From: shkwavrydr@aol.com
To: [Kelly Bacon \(CD\)](#)
Subject: Brown and Jackson Septage Lagoon SEPA Determination
Date: Monday, August 31, 2020 9:41:51 PM

There are significant questions about the SEPA Checklist submitted by Brown and Jackson for this proposal.

**BROWN & JACKSON**  
 Land Application Site  
 Preliminary  
 Site Map  
 Kittitas County  
 Washington

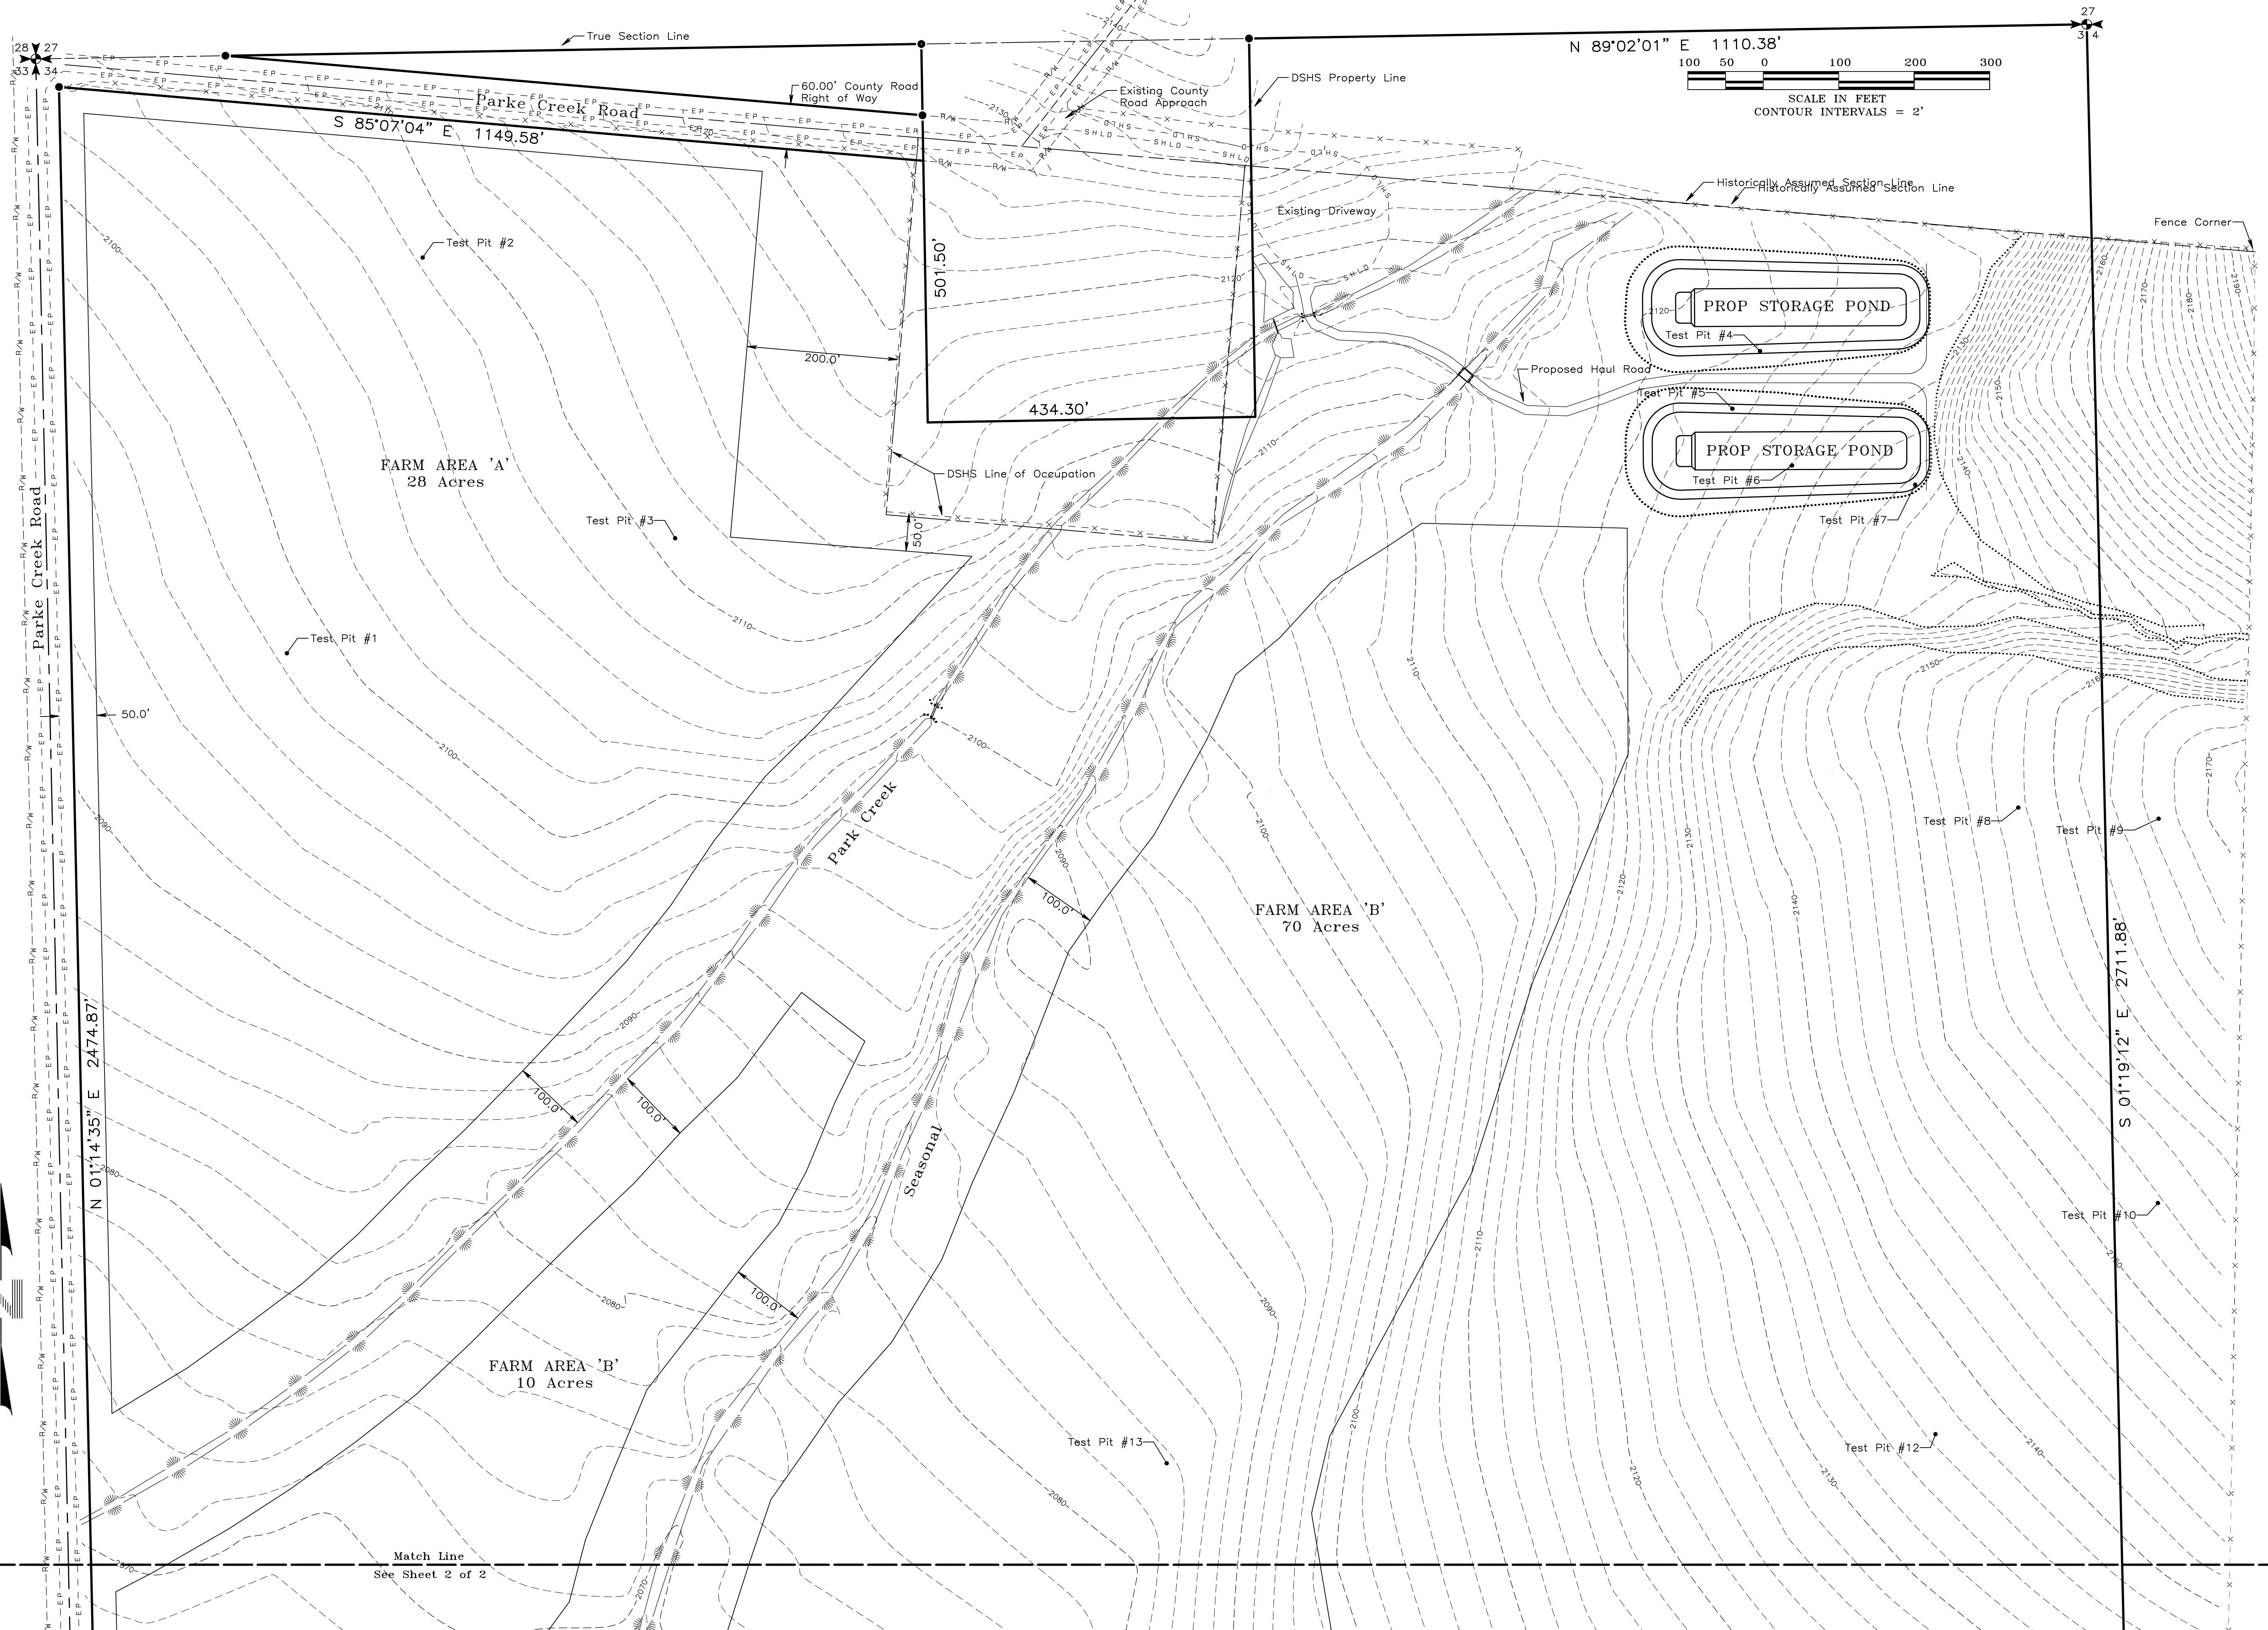
The "seasonal drainage" identified in site plans is also a water of the state. In limnological terms, these are termed "seasonal", "vernal" or "temporary" streams, and fall into the definition of "waters of the state" under RCW 90.48. Thus, whether or not this area is identified on County Shoreline maps as a shoreline, the proximity to this drainage may not meet offset requirements from waters of the State.
